Rezoning Transportation Analysis

Petition Number: 2020-007

General Location Identifier: Tax ID 11123334

Revision Log:

ERWIN CAPITAL/BEAVER FARMS TECHNICAL DATA SHEET

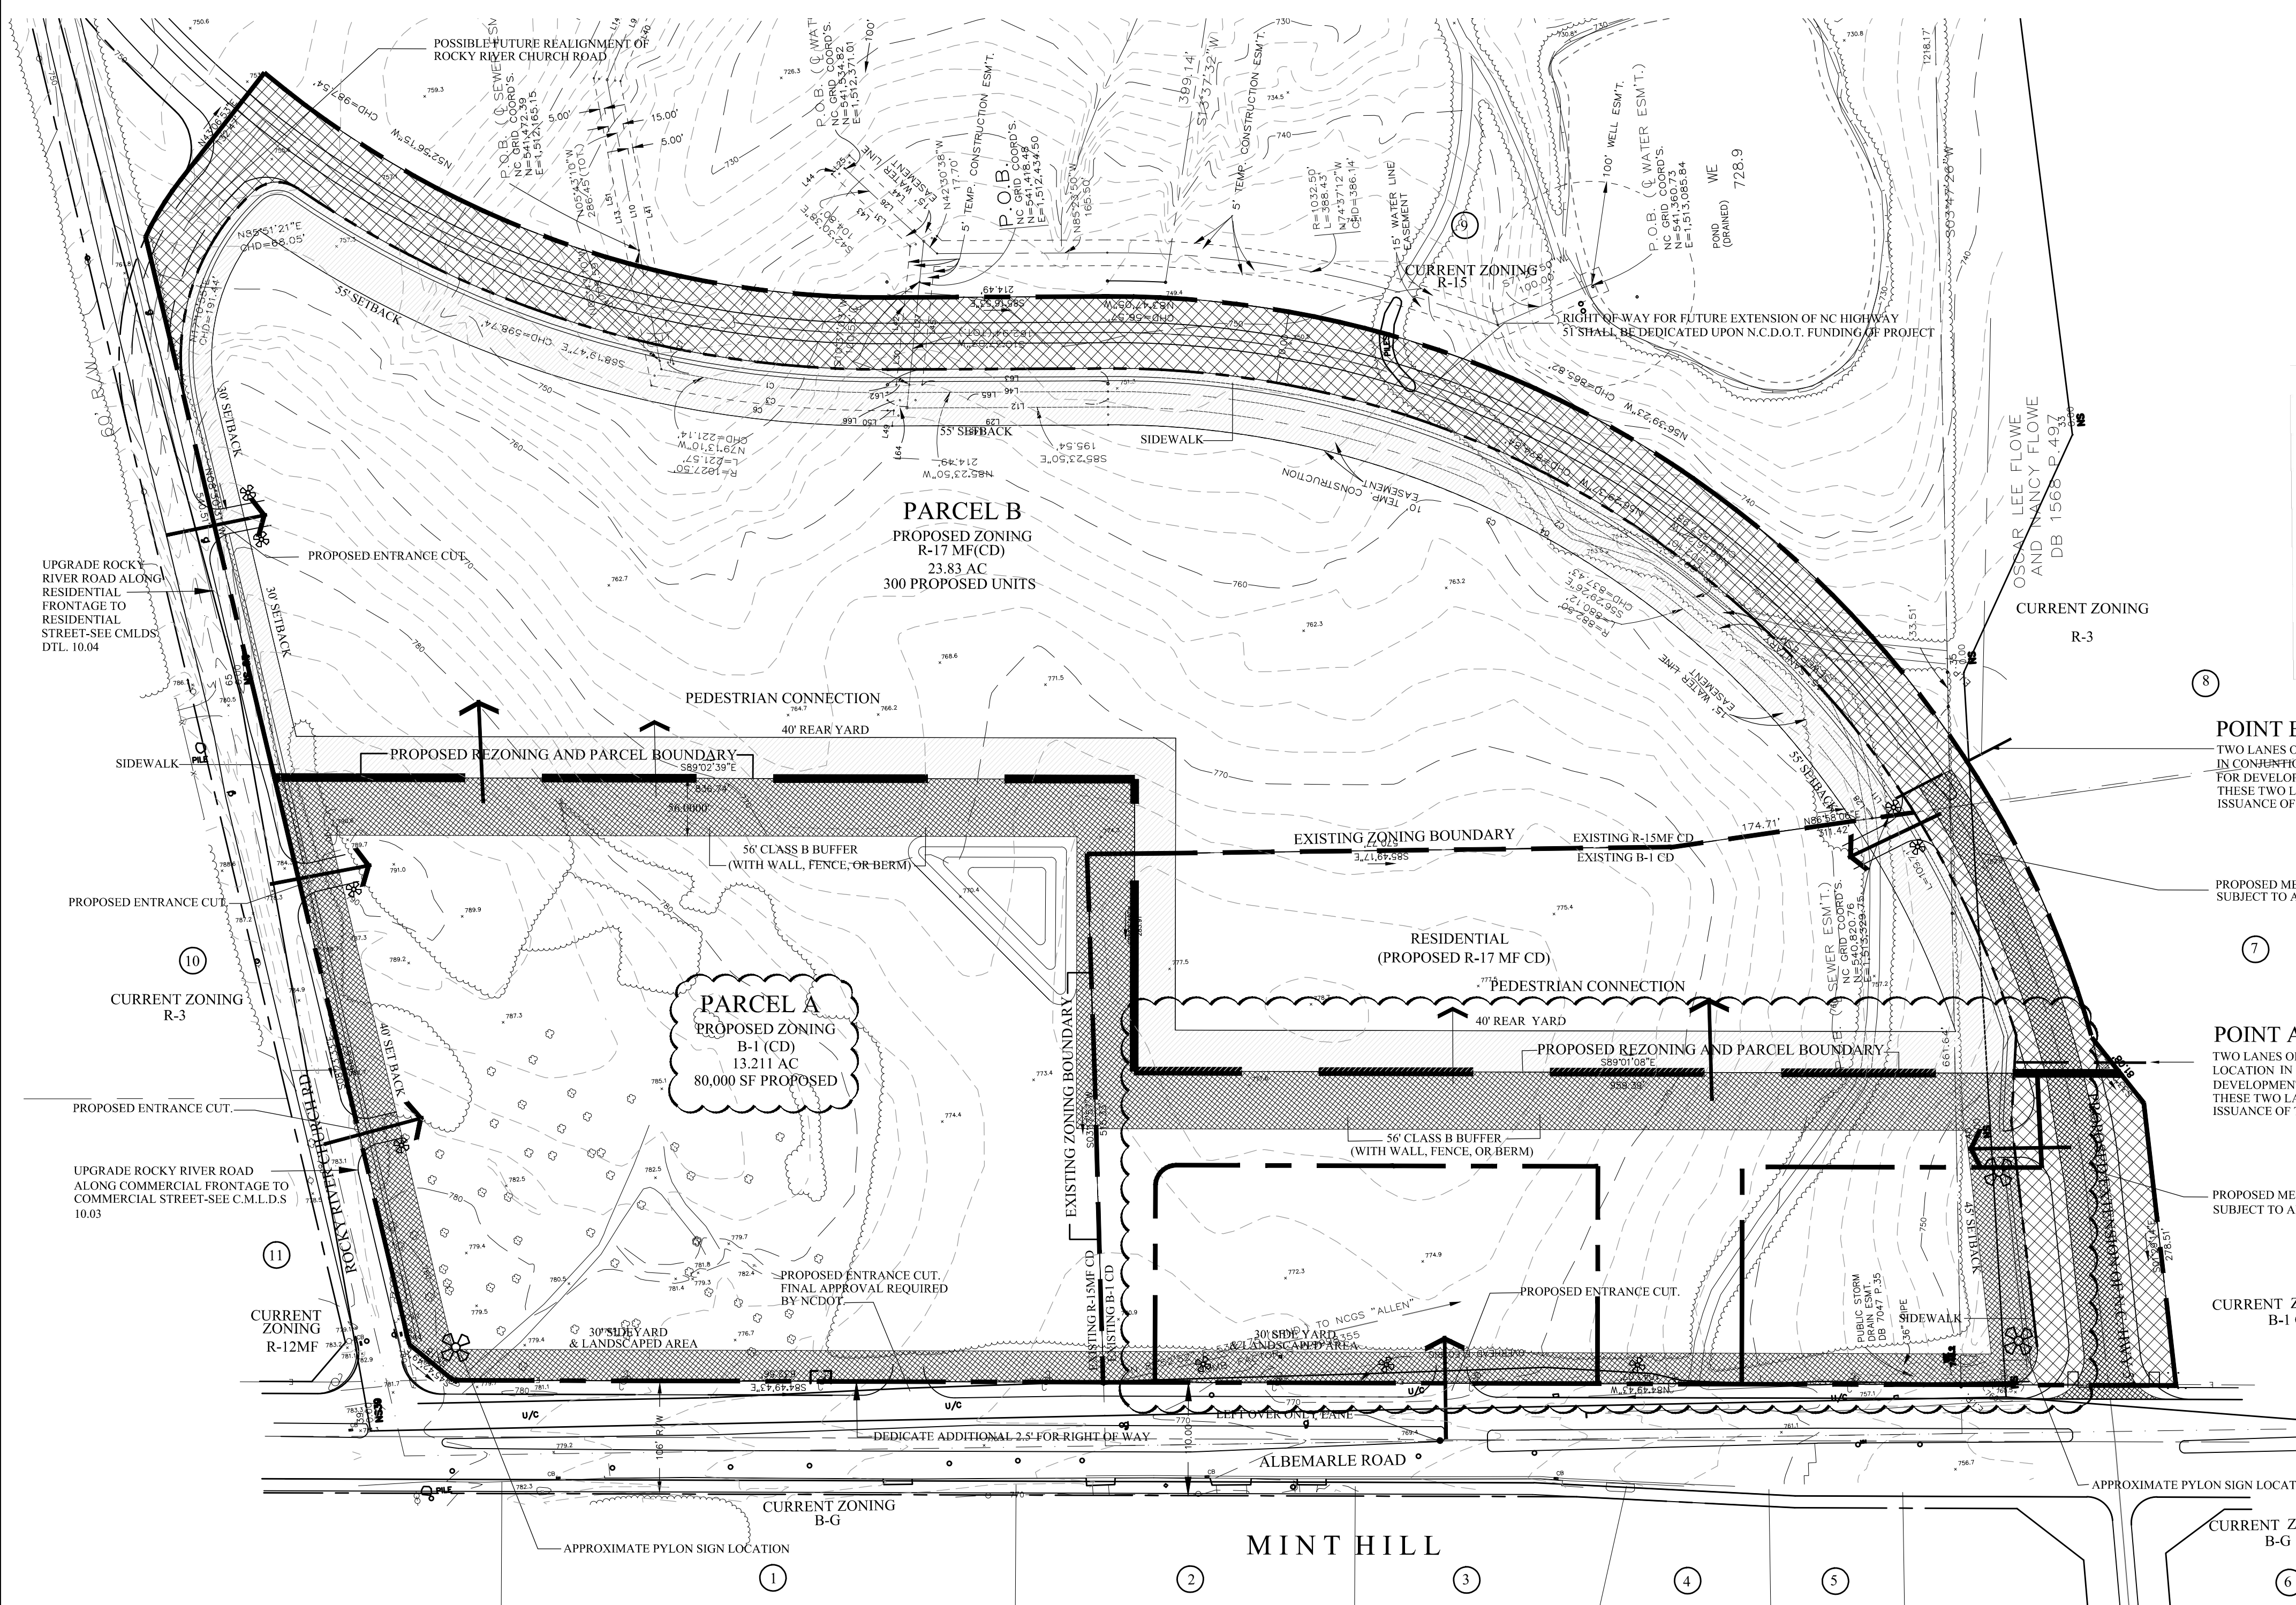
The site plan should show the curb and gutter labeled and dimensioned from the centerline for each road.

3. The petitioner should revise the site plan and conditional note(s) to commit to dedicate a minimum of 50 feet of right-of-way from the Albemarle Road centerline, per Chapter 12 of the Zoning Ordinance requirements for a Charlotte Regional Transportation Planning Organization (CRTPO) classified major thoroughfare. The site plan should label and dimension the right-of-way from the road centerline.

5. ~~The petitioner should revise the site plan and conditional note(s) to include two ADA curb ramps at each curb return.~~
6. The petitioner should revise the site plan to add a note specifying dedication and fee simple conveyance of all rights of way to the City before the site's first building certificate of occupancy is issued. CDOT requests right of way set at 2' behind back of sidewalk where feasible.
7. ~~The petitioner should revise the site plan to add a note specifying all transportation improvements will be approved and constructed before the site's first building certificate of occupancy is issued. The petitioner may phase transportation improvements if said improvements and phasing are explicitly described in site plan notes.~~
